Our ref: AC/2022/130910/01-L01
Your ref: EN010106
Date: 16 March 2022

APPLICATION FOR DEVELOPMENT CONSENT ORDER - SUNNICA ENERGY FARM - RELEVANT REPRESENTATION ON BEHALF OF THE ENVIRONMENT AGENCY

The submitted Flood Risk Assessment (FRA), ref. EN010106/APP/6.2, dated 21 January 2021 is considered to be unacceptable for the following reasons:

Drawing Title
**FIGURE 3-19A
CONSTRUCTION COMPOUNDS &
ACCESS SUNNICA EAST
SITES A AND B**

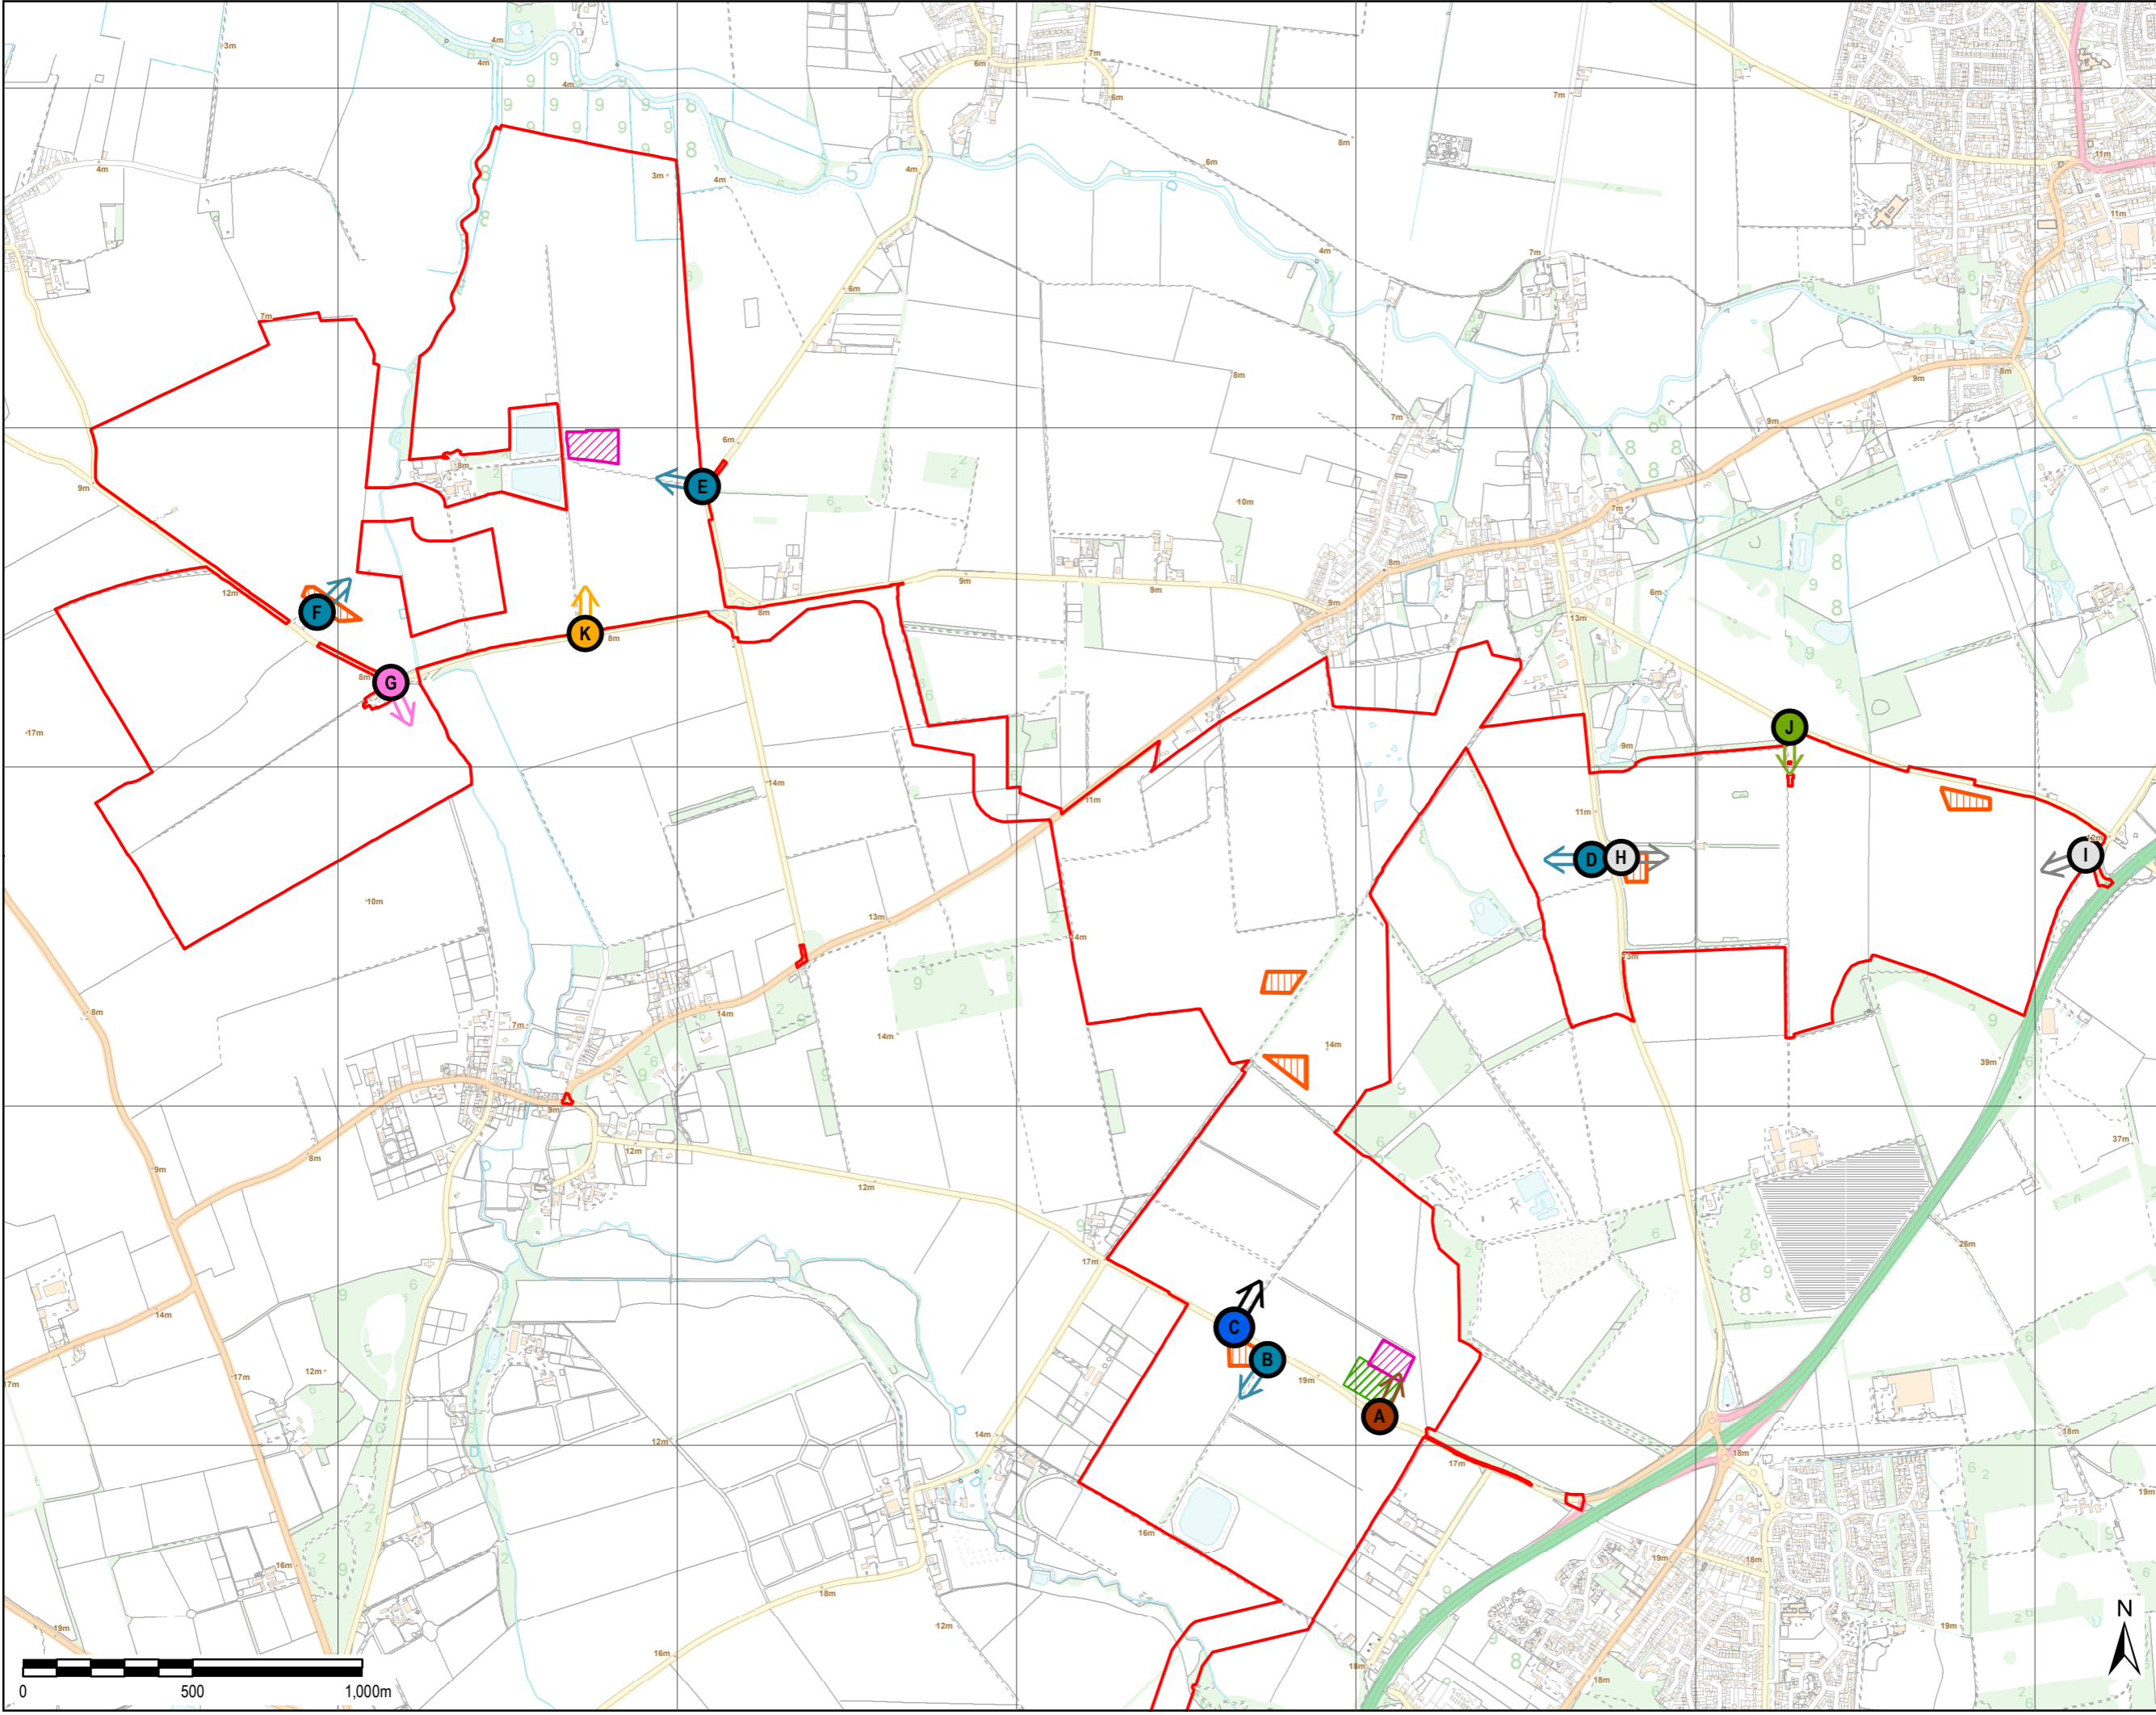
No drawings have been included in the FRA to show the proposed location of any temporary site compounds and storage areas in relation to the flood zone extents. All site compound areas / storage areas should be located outside the extent of Flood Zone 3, or outside the 1 in 100 year modelled flood extent, to ensure there is no loss of floodplain and no increase in flood risk elsewhere during the construction phase.

Drawings should be included in the FRA which clearly show the location of any proposed temporary site compounds and storage areas in relation to the extent of Flood Zones 2 and 3. If any temporary site compounds or storage areas need to be located within the floodplain then it will need to be demonstrated that adequate floodplain compensation can be provided to ensure there is no increase in flood risk elsewhere.
